**Consultation Response from KC,
Highways Development Management**

2025/91542 Land at, Highmoor Lane, Hartshead Moor, Cleckheaton, BD19 6LW

**Erection of 40 dwellings and associated works, including formation of new vehicular access
and erection of cricket netting**

Date Responded: 1-10-2025.

Phoenix 2 Duo (P2-15W with Elite 6x4 chassis)
 Overall Length 11.200m
 Overall Width 2.530m
 Overall Body Height 3.751m
 Min Body Ground Clearance 0.304m
 Track Width 2.500m
 Lock to lock time 4.00s
 Kerb to Kerb Turning Radius 9.500m

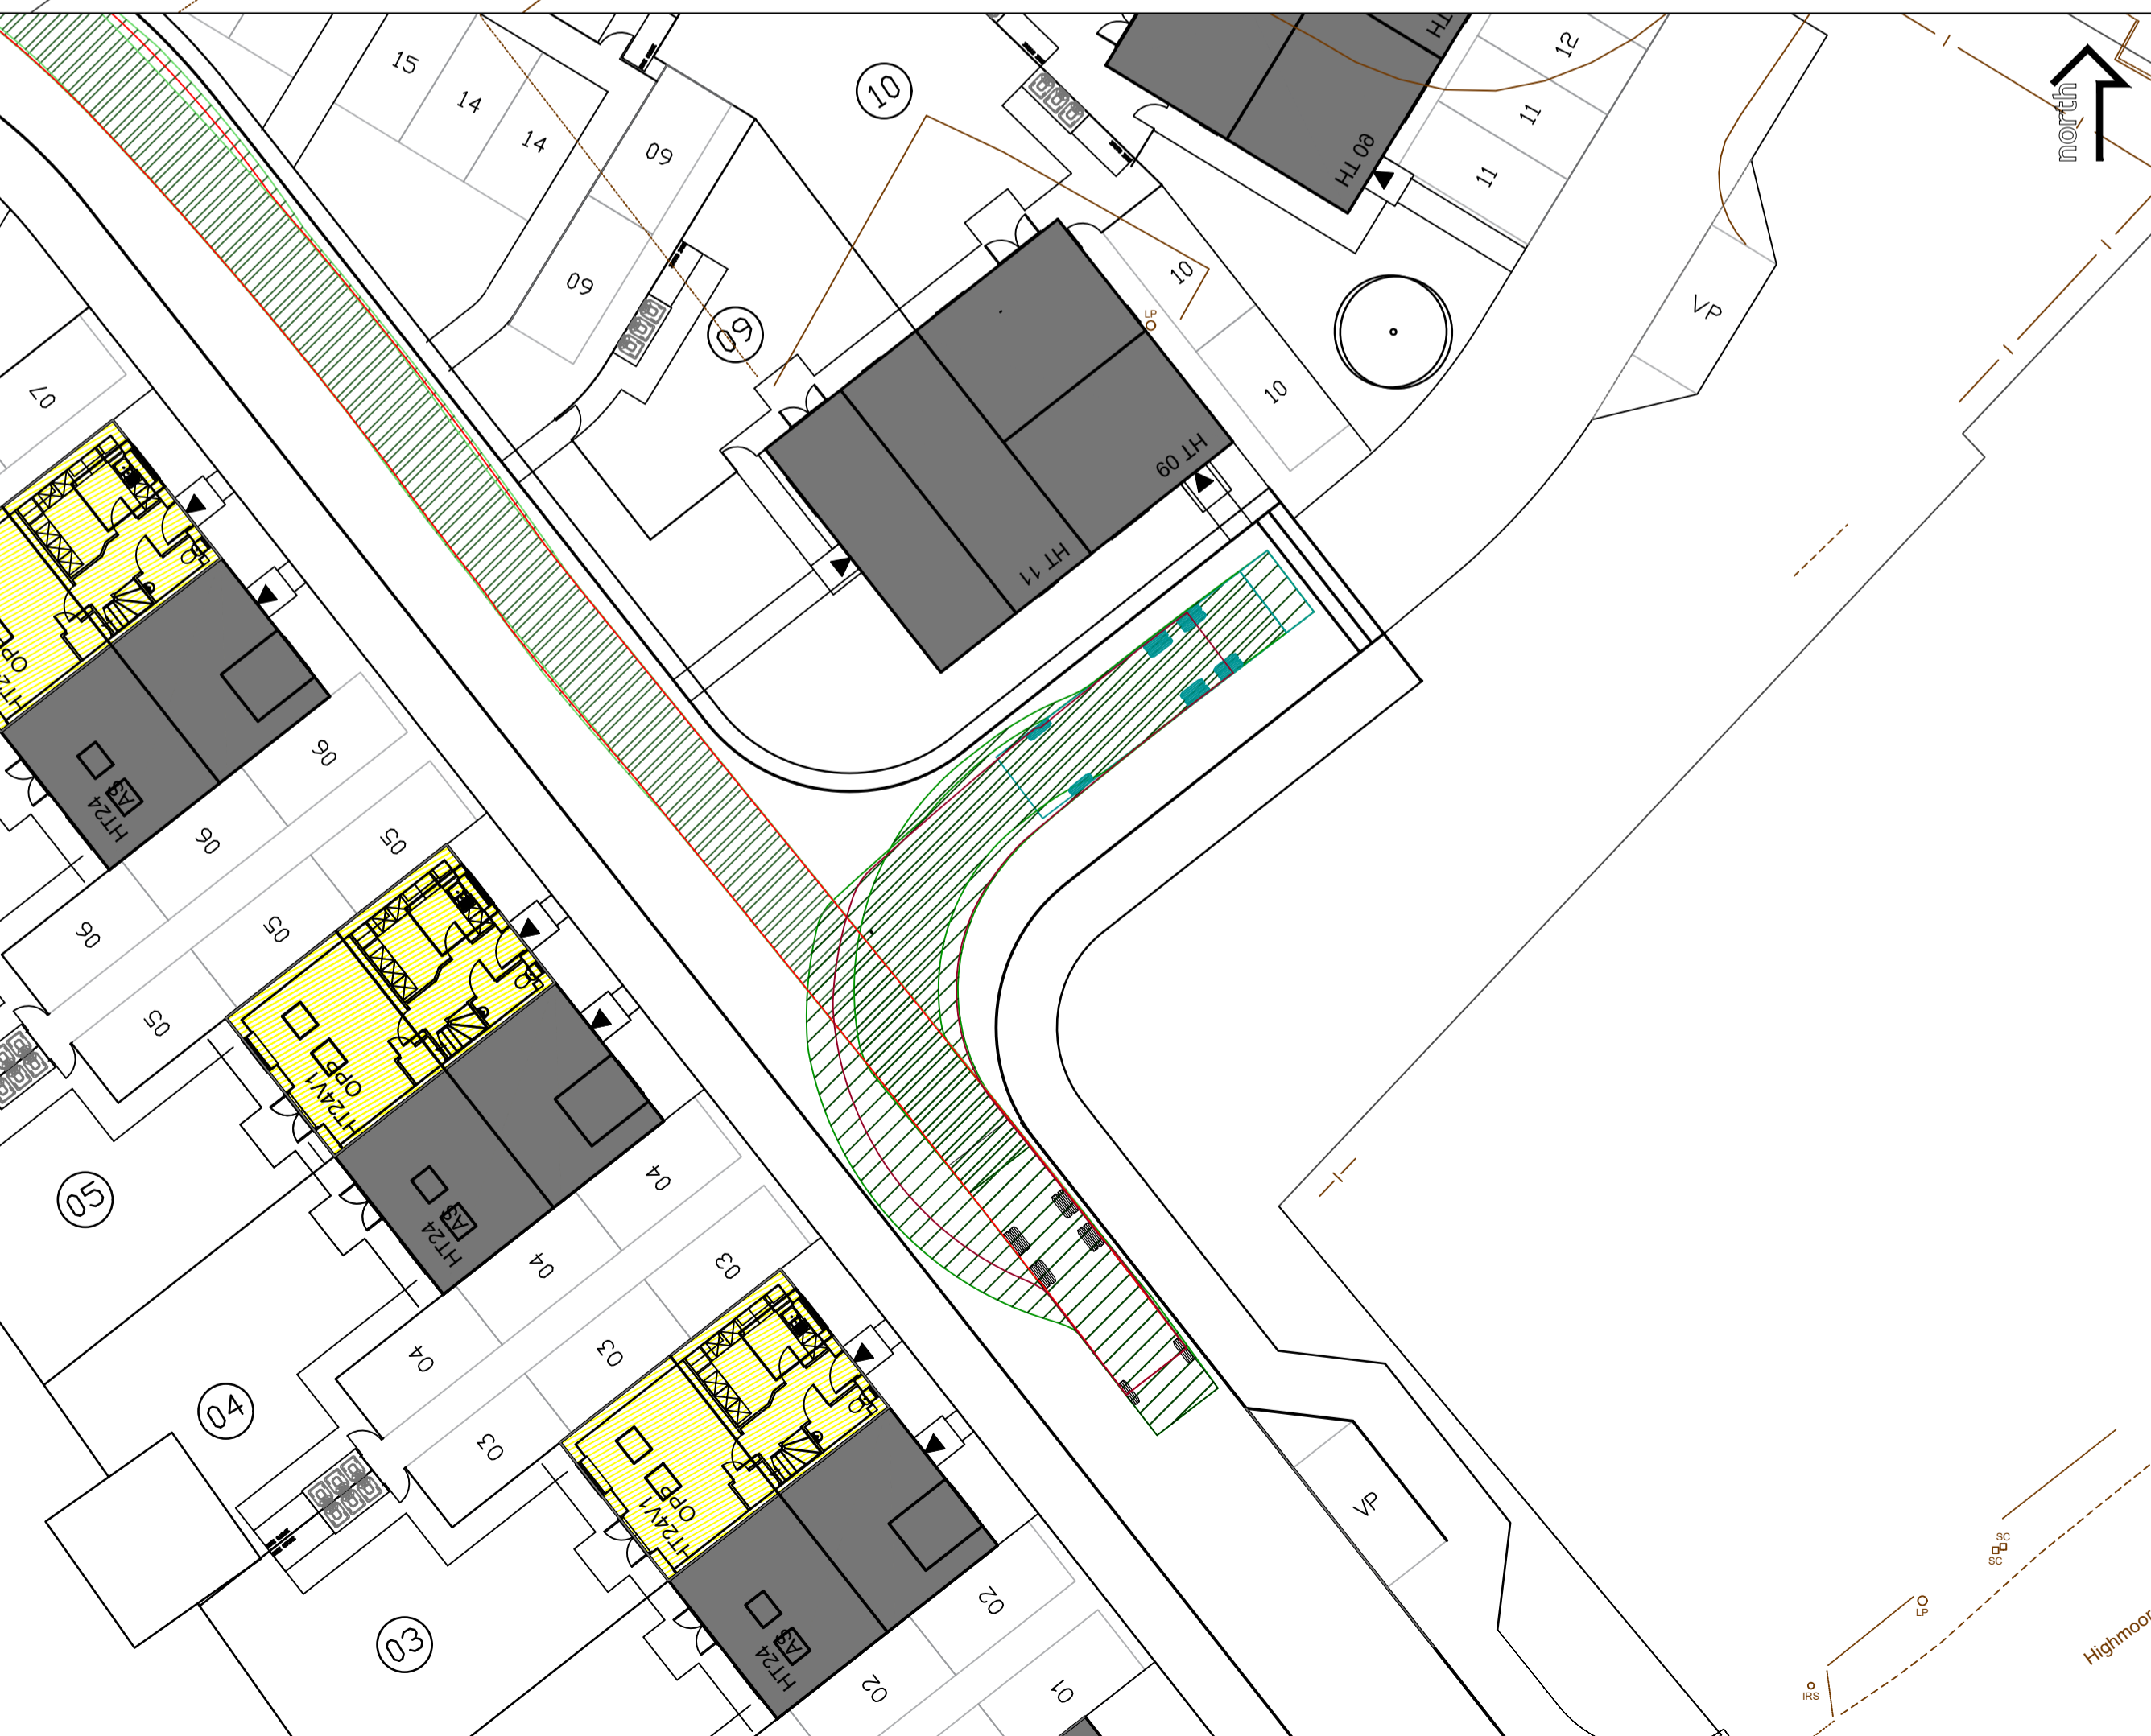
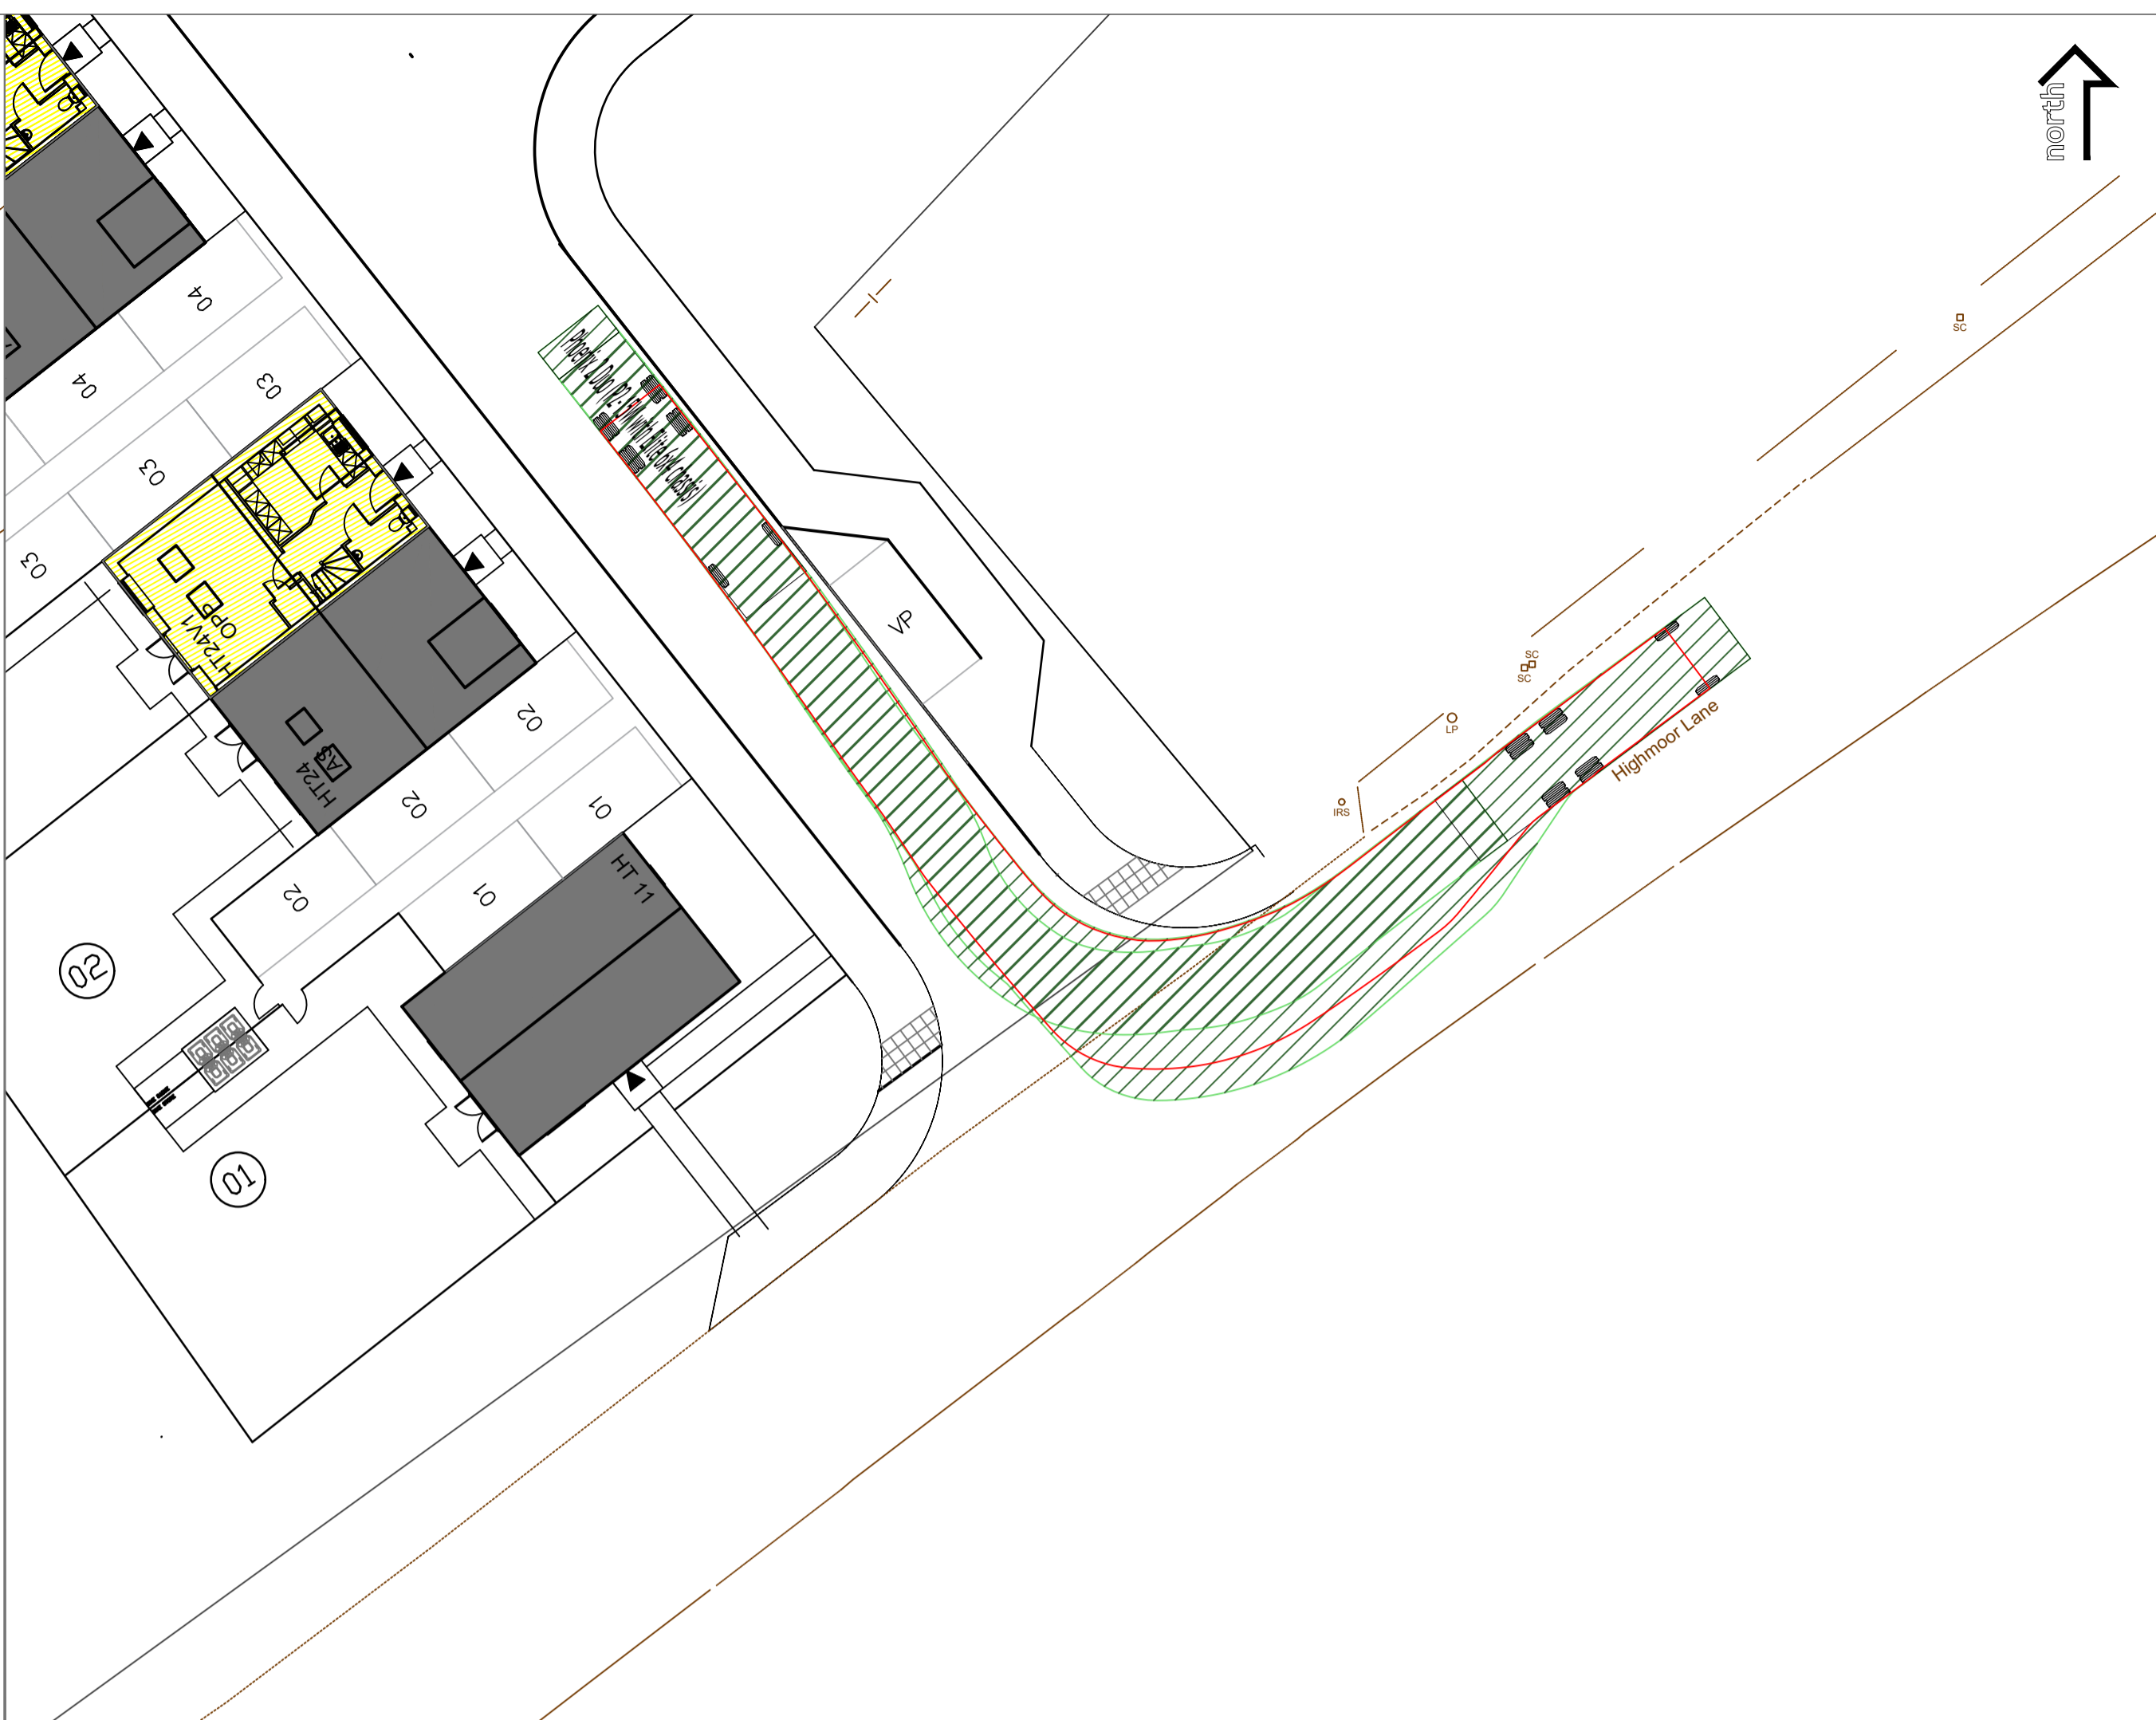
Swept paths for an 11.85m refuse vehicle should be used and not the 11.2m vehicle shown on the Transport Statement.
